**Our ref:** NO/2019/112169/03-L01  
**Your ref:** 3/2019/0930

**PROPOSED EXTENSION TO FACTORY AND CREATION OF NEW CAR PARK WITH ACCESS.**

**CLITHEROE LIGHT ENGINEERING, UNITS A-C, UPBROOKS INDUSTRIAL ESTATE, CLITHEROE, BB7 1PL.**

PHA/CLAV100 OCTOBER 2019

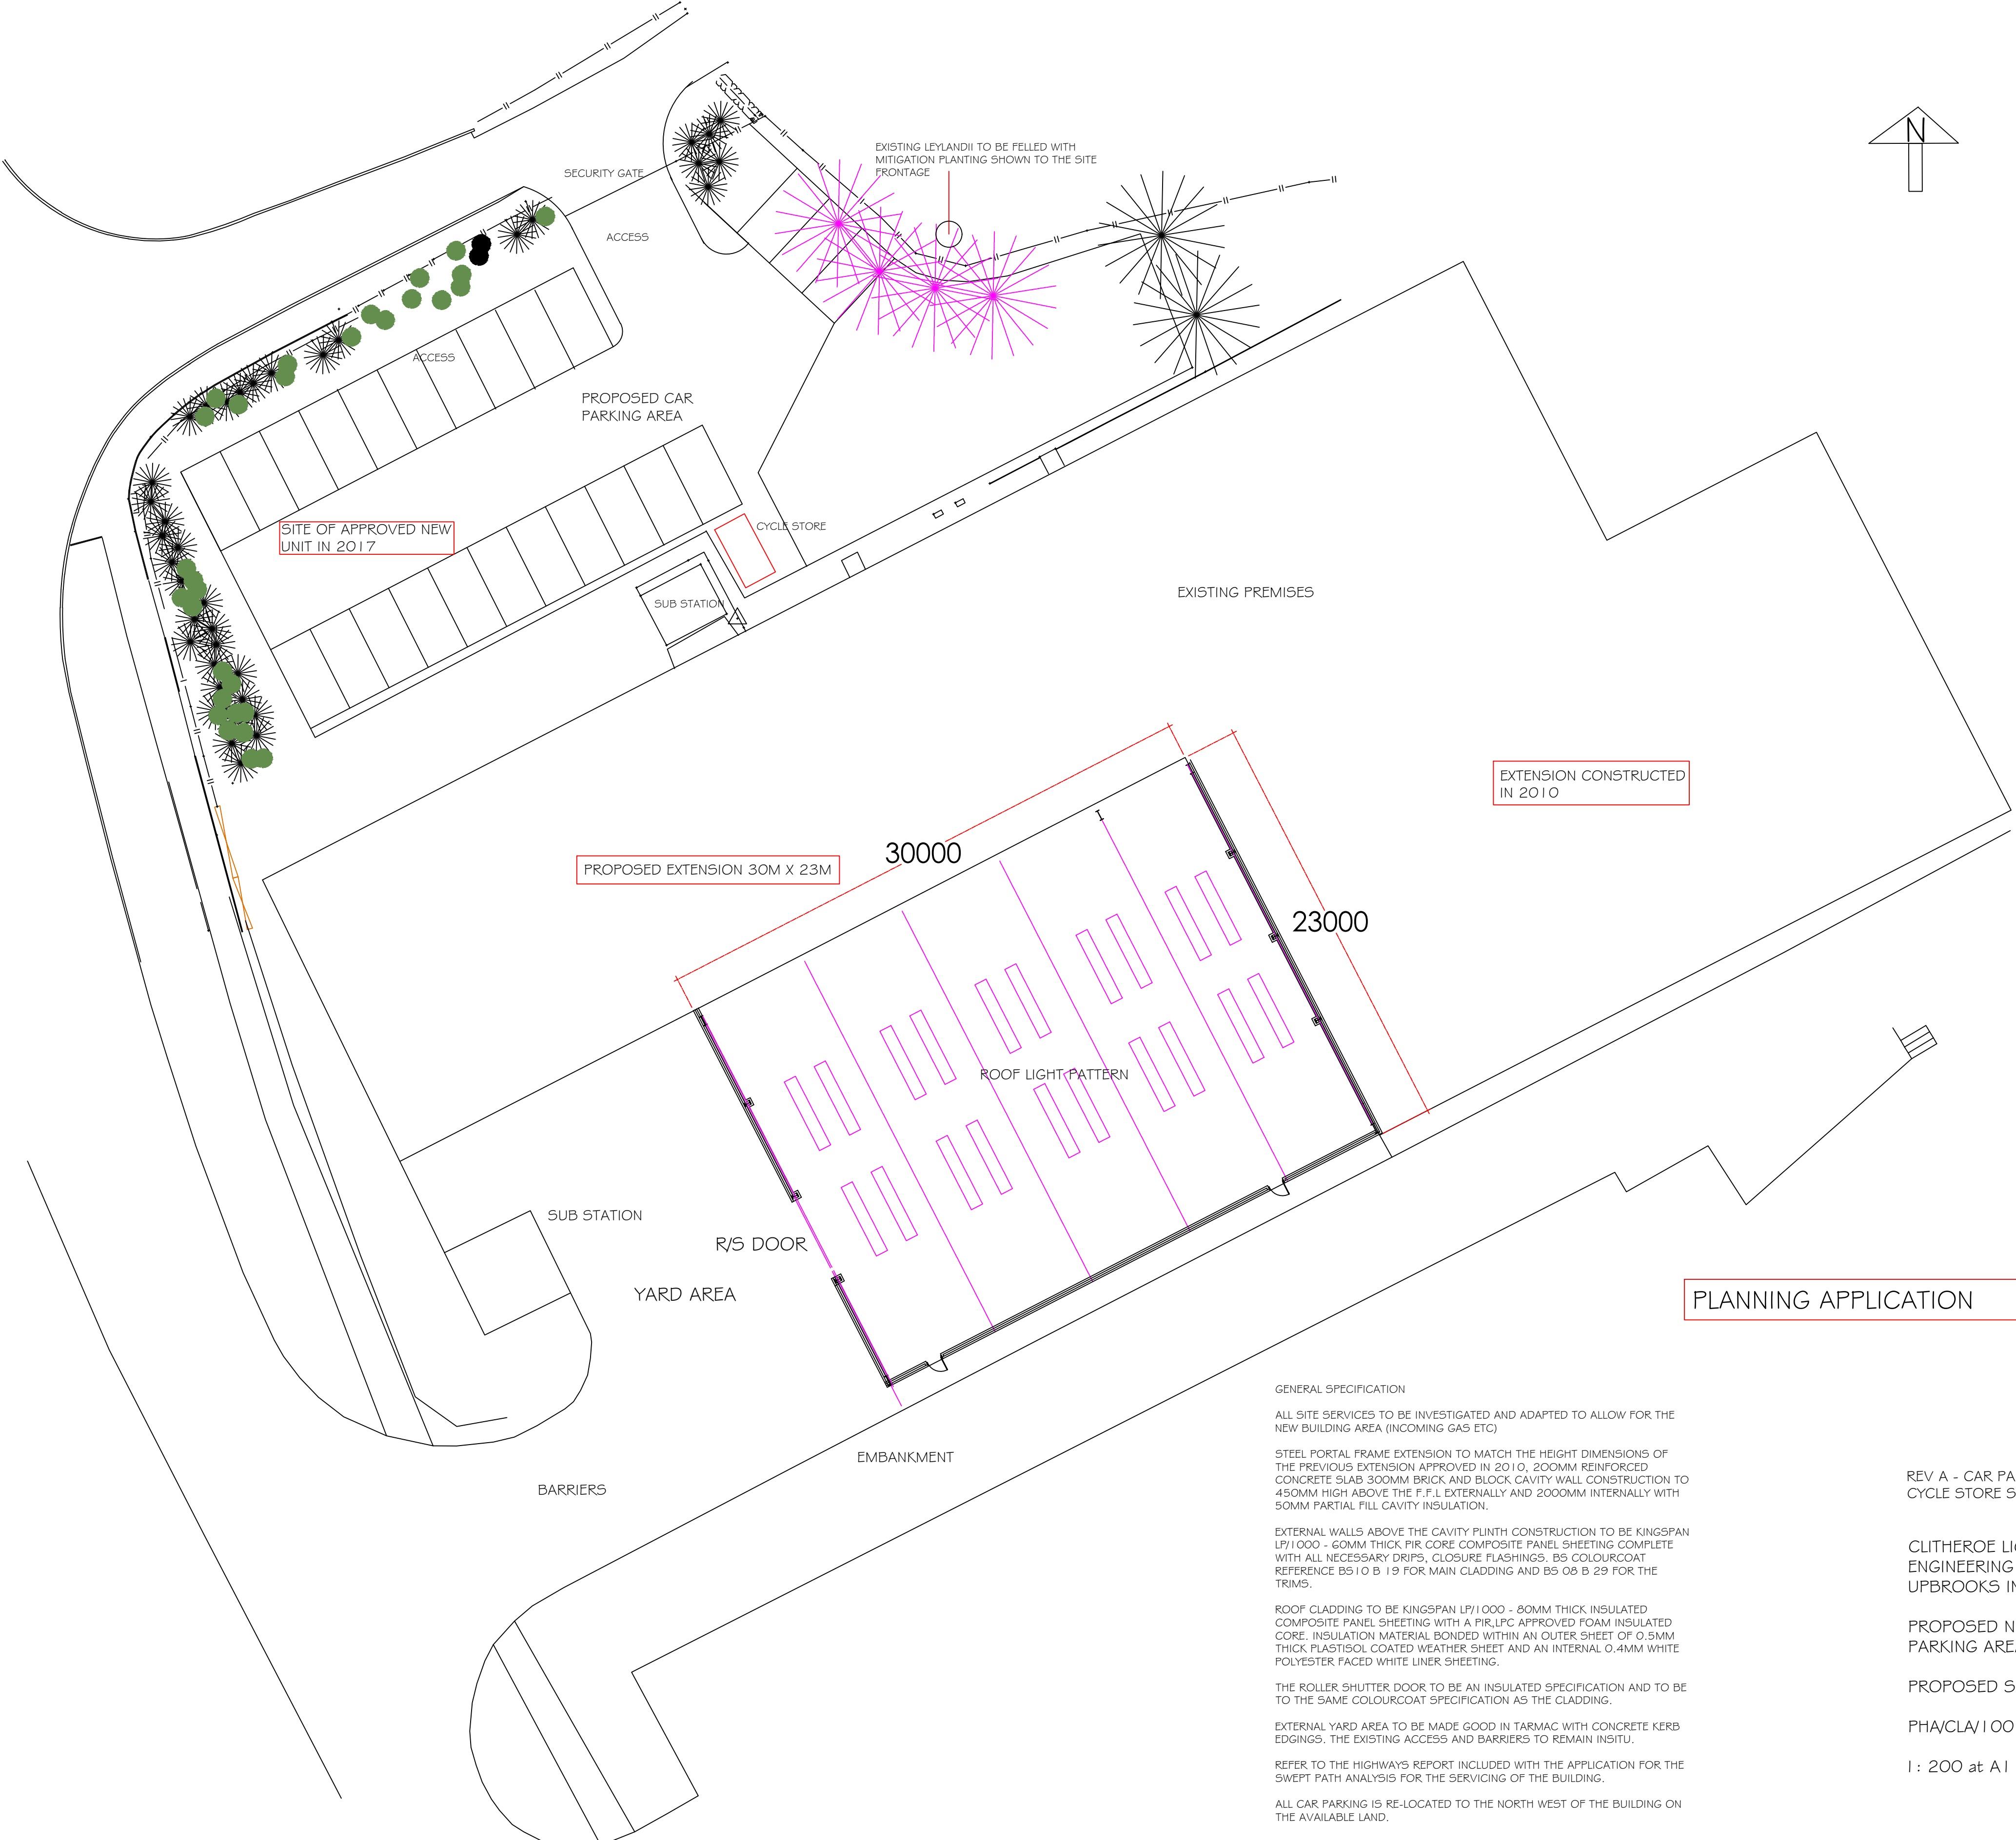
We have reviewed the revised plan, reference PHA/CLA/400 dated October 2019 with annotations added to indicate proposed carpark levels. We have no objection to the development as proposed, subject to the inclusion of the following condition.

The development shall be carried out in accordance with the submitted plan, reference PHA/CLA/400, dated October 2019 and there should be no raising of ground levels within any part of the car park within the flood plain.

- To prevent the risk of flooding by ensuring that there is no loss of flood storage as a result of the proposed development.
